Our Ref: R/237/18/HH
Your Ref:

Town & Country Planning Act 1990 (as amended)
Town & country Planning (Development Management Procedure) (England) Order 2015
Application for Planning Permission for Works or Extension to a Dwelling

Development Front porch and front extension
Location 4 Mill Close Rustington

PROPOSED 1:50

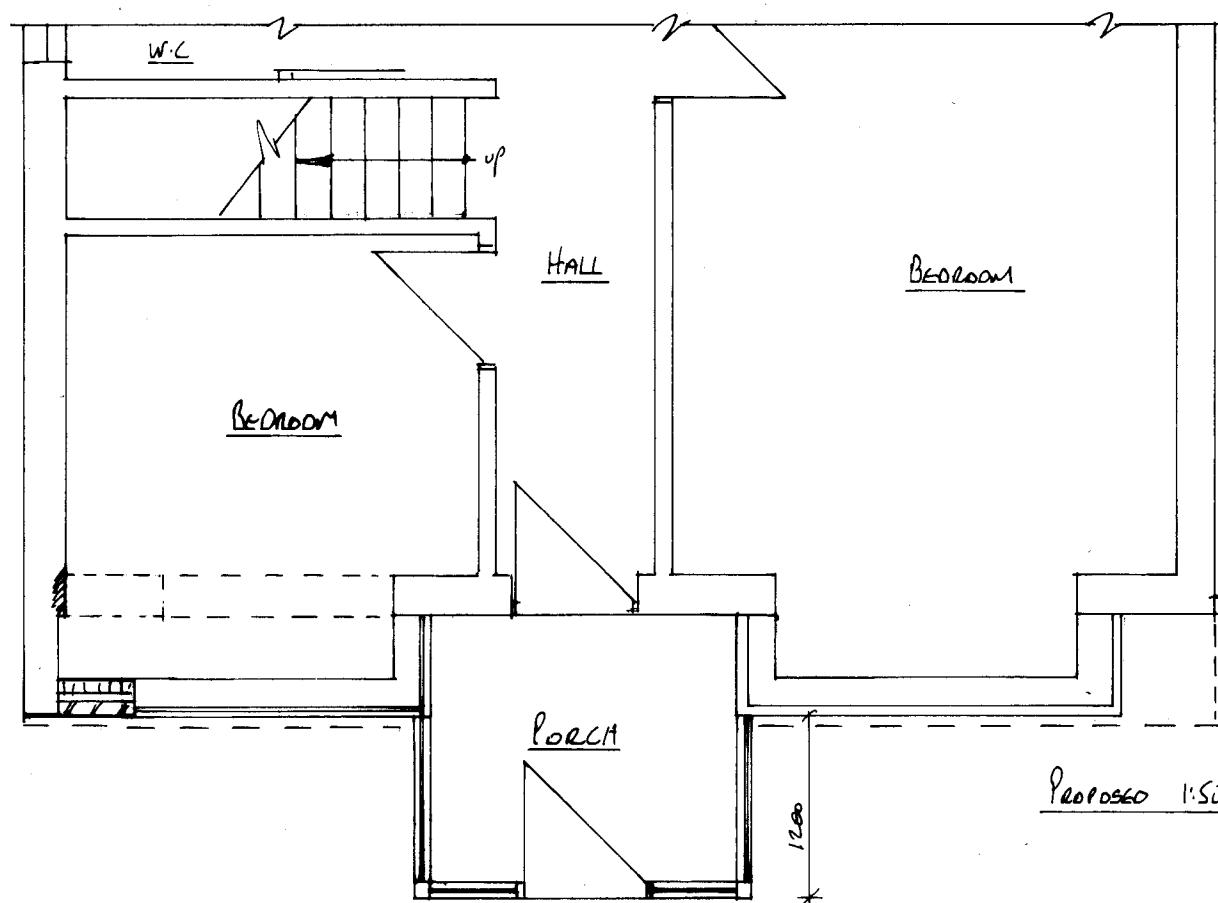
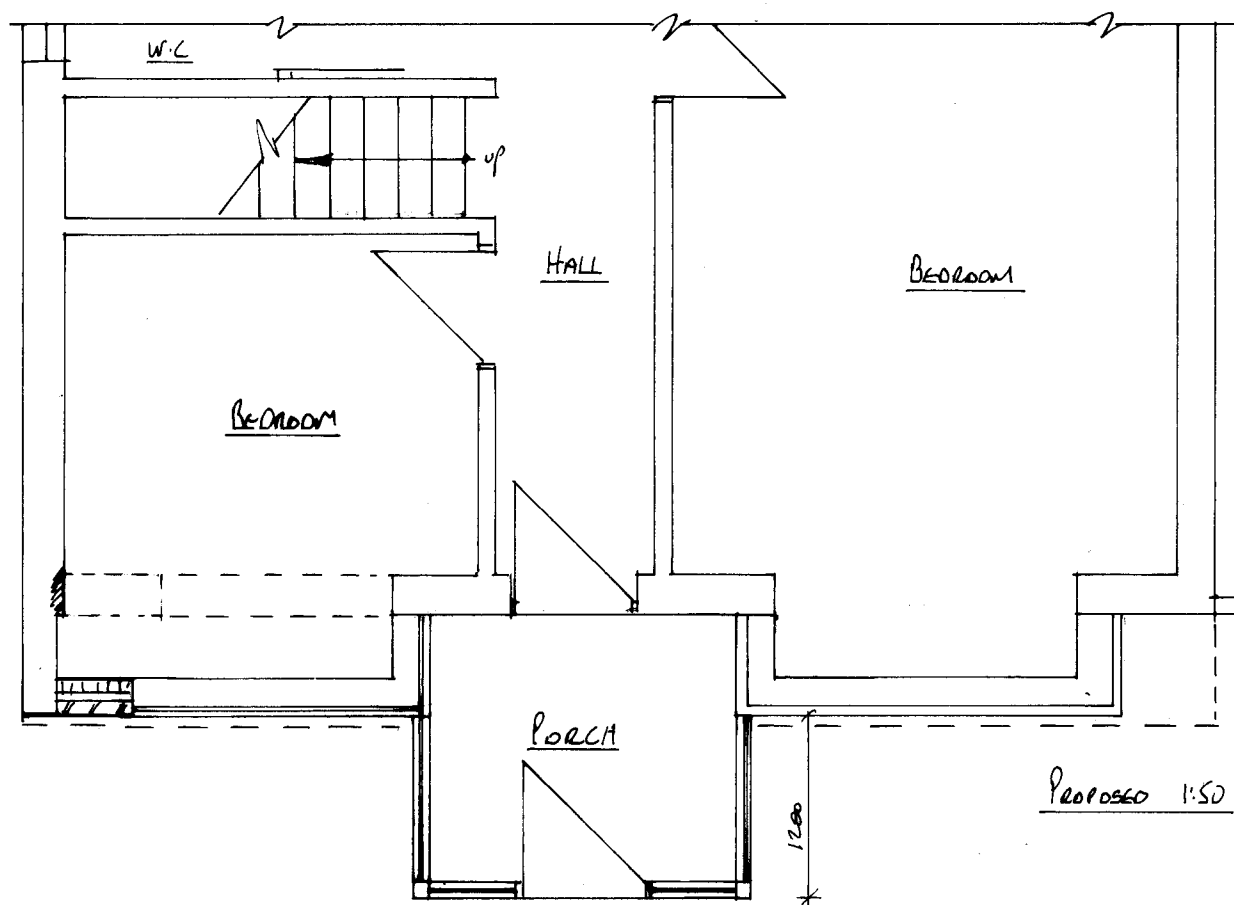
Plans Inconsistent

The width of the porch does not match between the proposed floor plan and block plan.

Block Plan 1:500

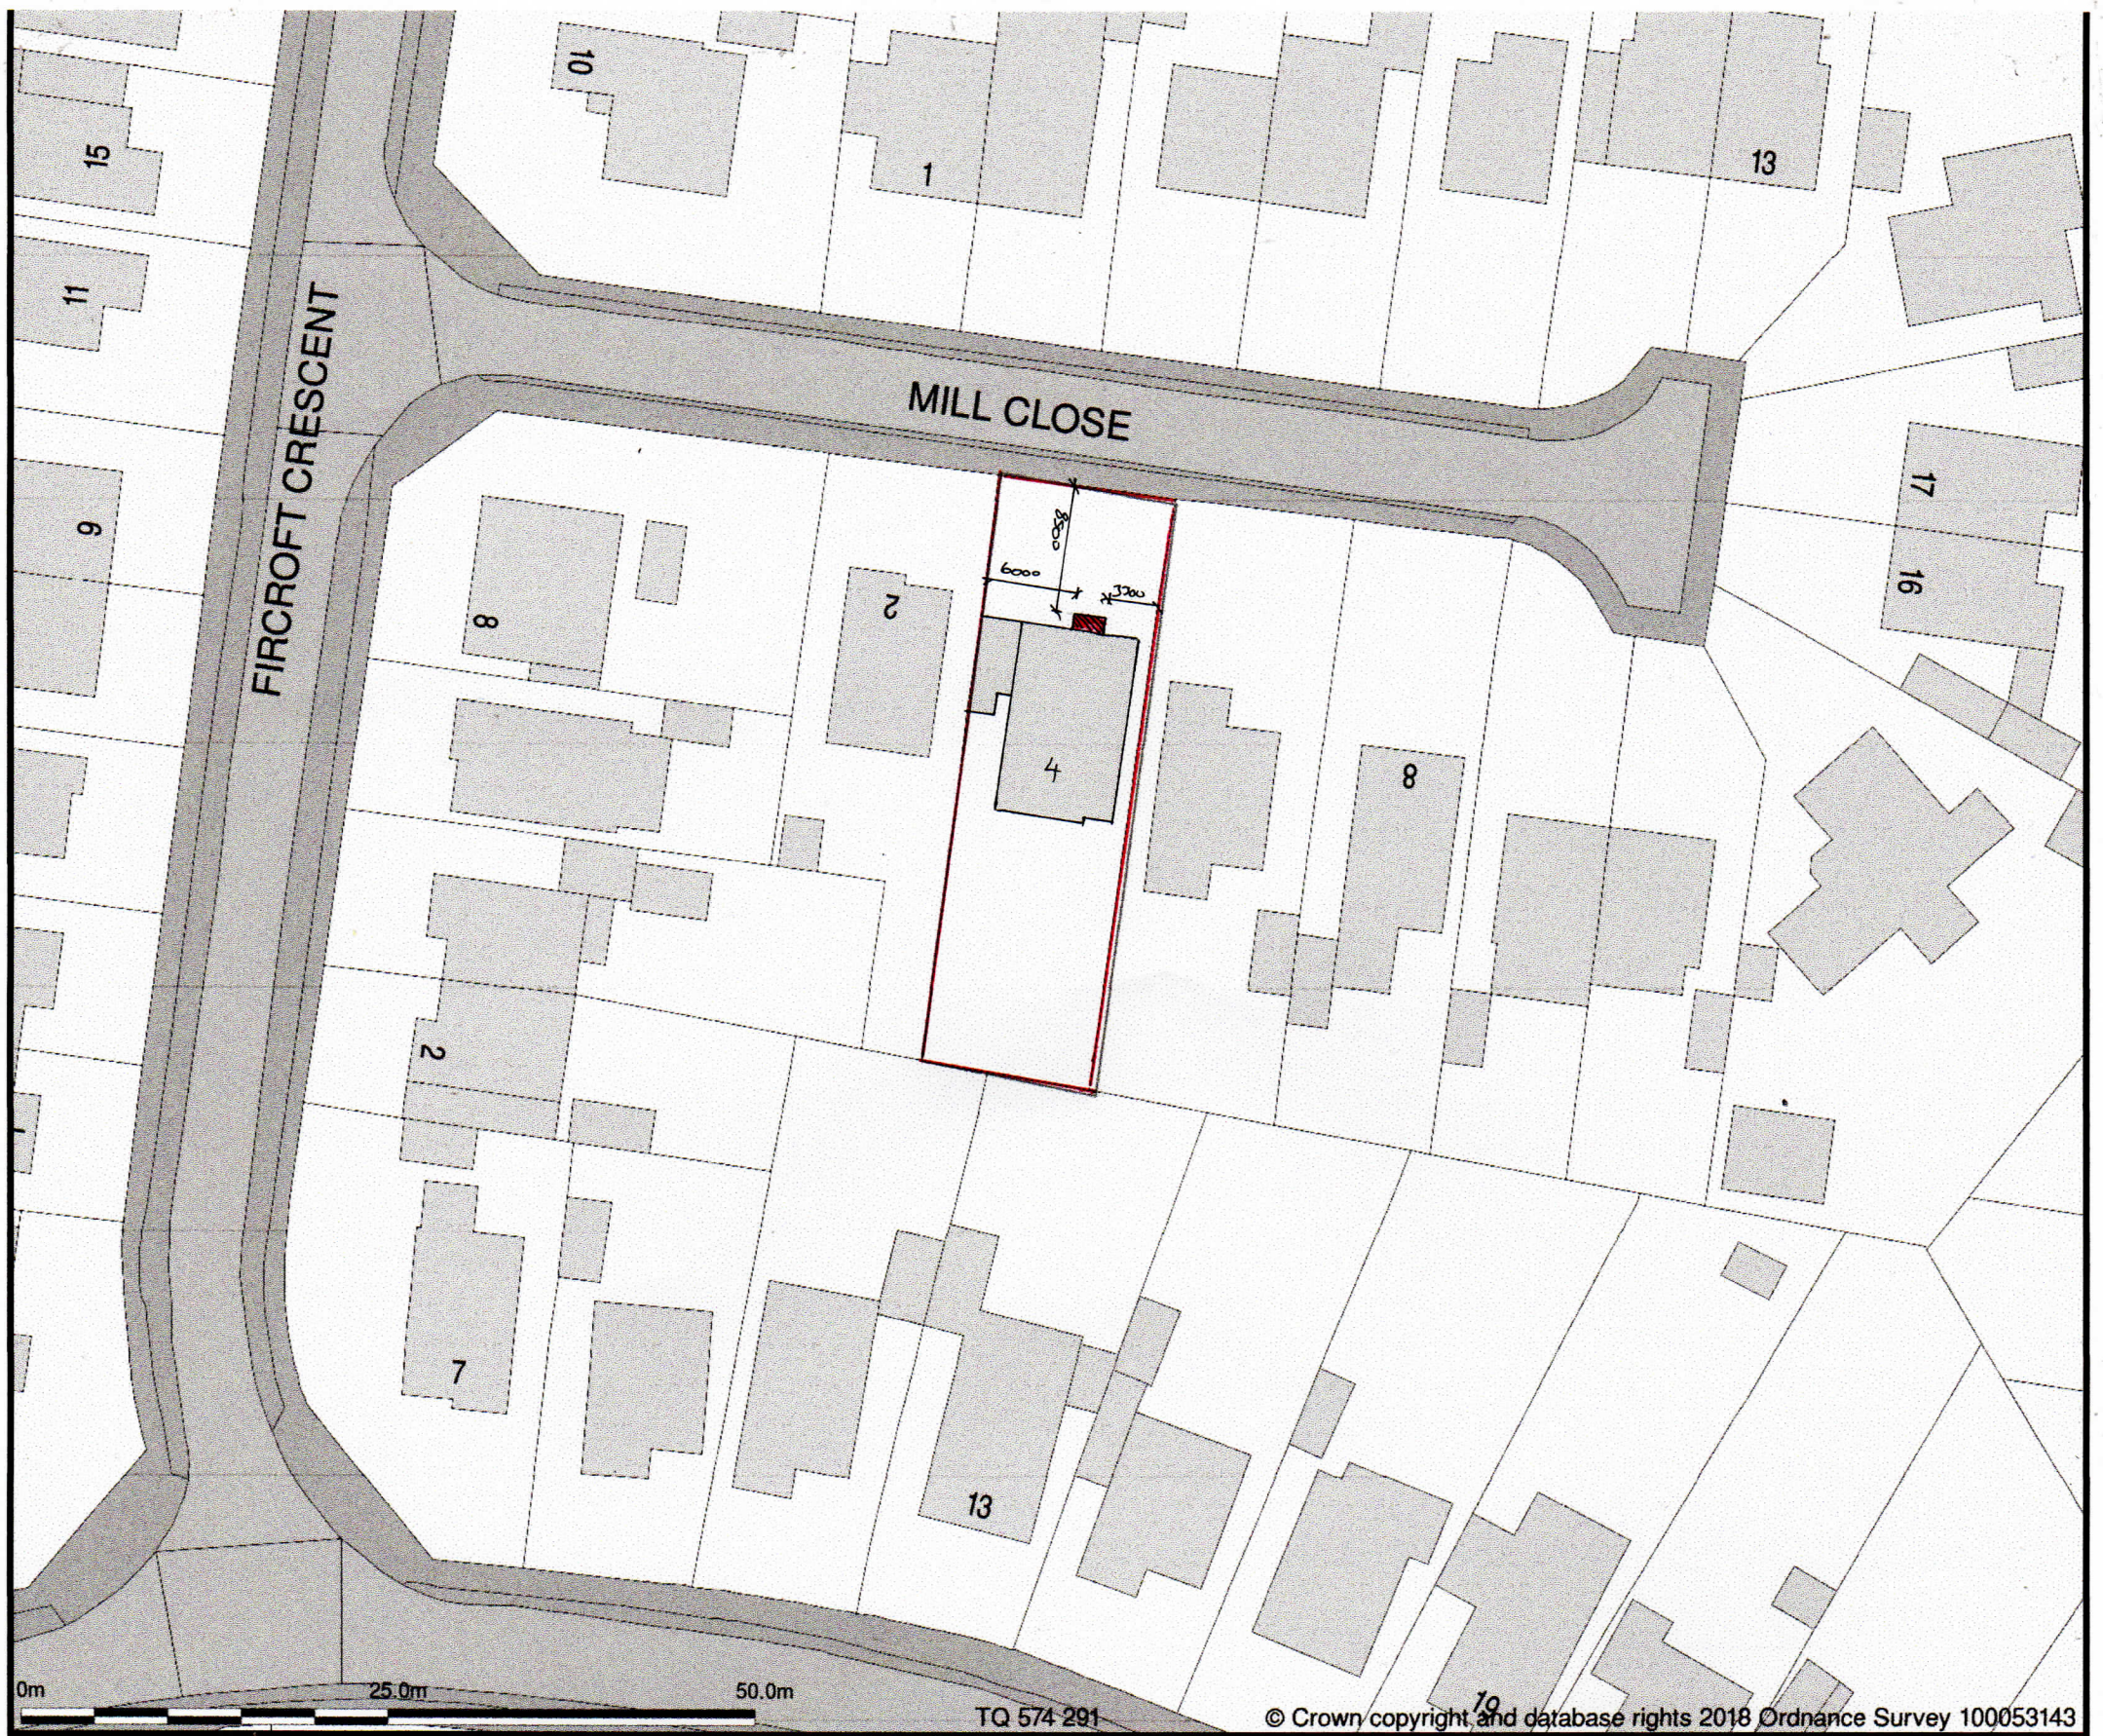
Block Plan

You are required to show all dimensions from the proposed extension to the boundaries.
